**Notice of Exhibition – Moorebank Precinct East (MPE): Stage 2 Application SSD 7628**

Reference is made to the ongoing discussions regarding the subject proposals. This is the combined response of Transport for NSW and Roads and Maritime Services (collectively referred to as TfNSW).

## Annexure A – Summary of TfNSW Issues

Figure 4-5 Indicative cross section – Moorebank Avenue 4 lane configuration

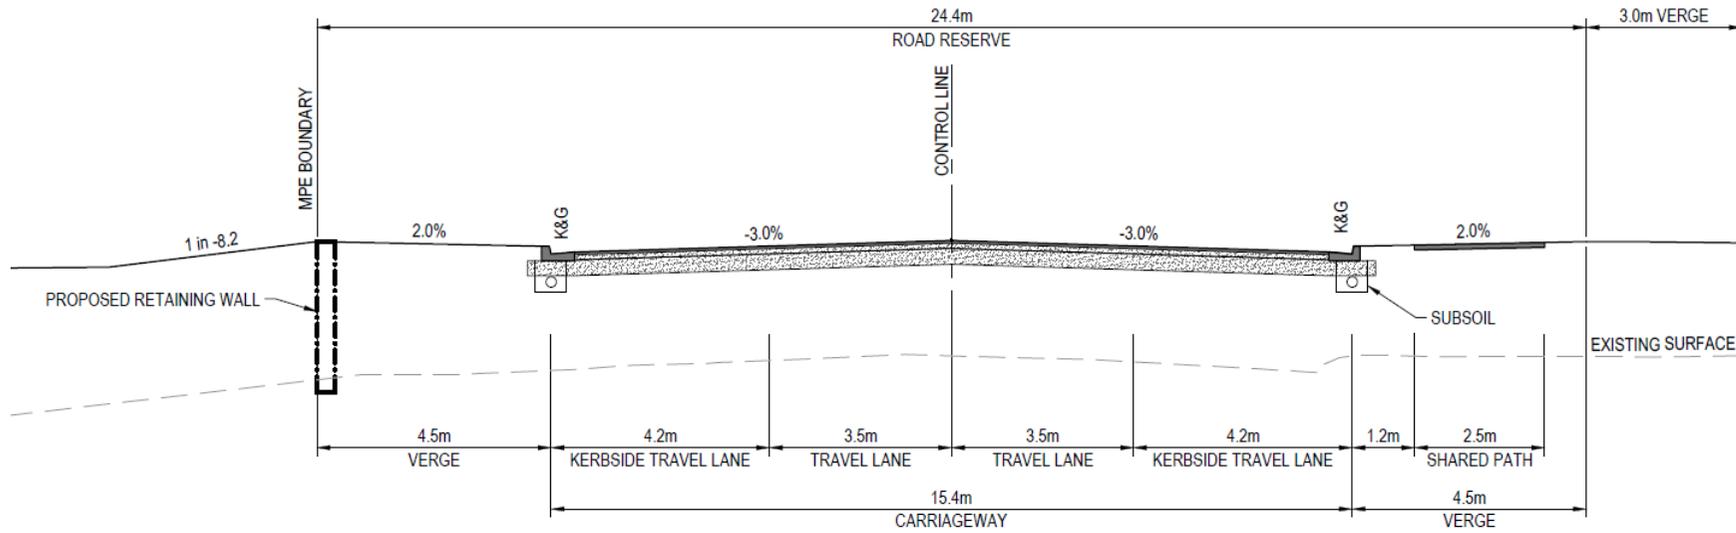
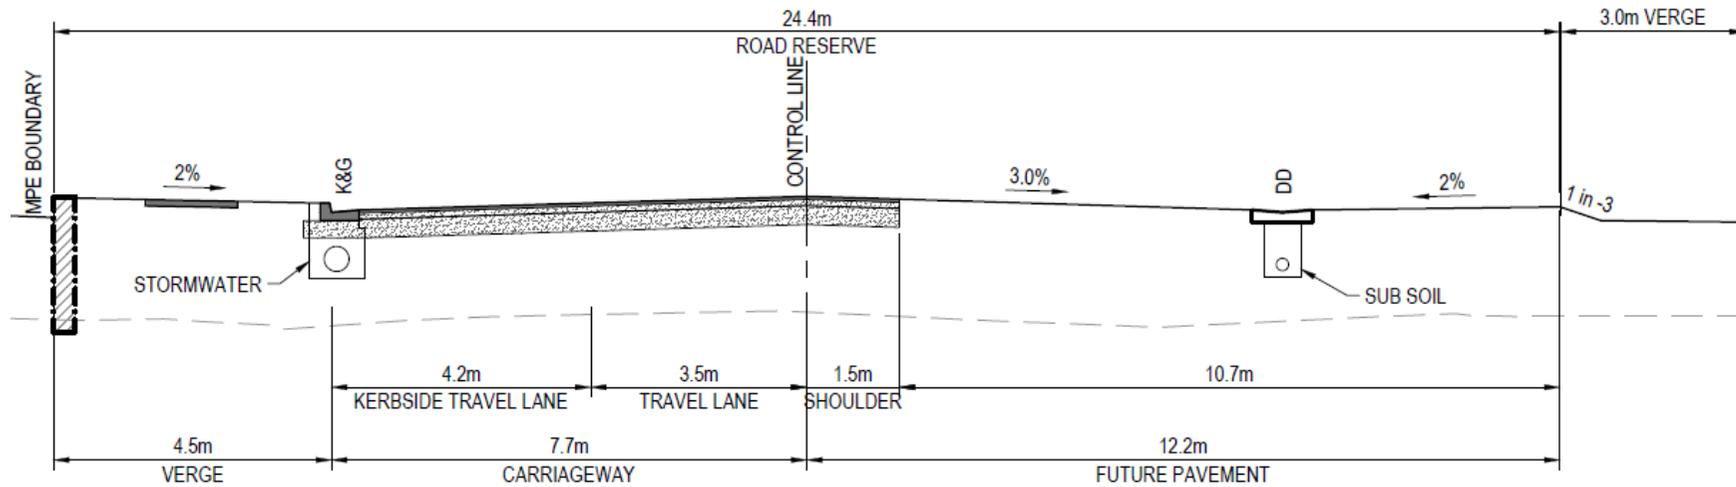
- Section 1.8 of the Operational Traffic and Transport Impact Assessment report states that Moorebank Avenue would be upgraded for 1.4km, commencing from approximately 95m south of the northern boundary of the MPE site to approximately 120m south of the southern MPE site boundary. A preliminary layout of the proposed Moorebank Avenue upgrade has been provided in Appendix D of the Operational Traffic and Transport Impact Assessment report, however further details are requested regarding the following:

- I. Lane configurations – how will the proposed lane widening works affect existing signalised intersections and approved construction access arrangements for MPE Stage 1 and MPW Concept Plan and Early Works applications.

- III. Road alignment – further details regarding the proposed change in level of Moorebank Avenue by up to 2 metres is required, including but not limited to; cross-sections, verge treatment, hydrology and stormwater management, service impacts, boundary levels and tie-ins. Staging plans will need to demonstrate how 2 lanes of traffic will be maintained along Moorebank Avenue, whilst the road is raised by 2 metres.
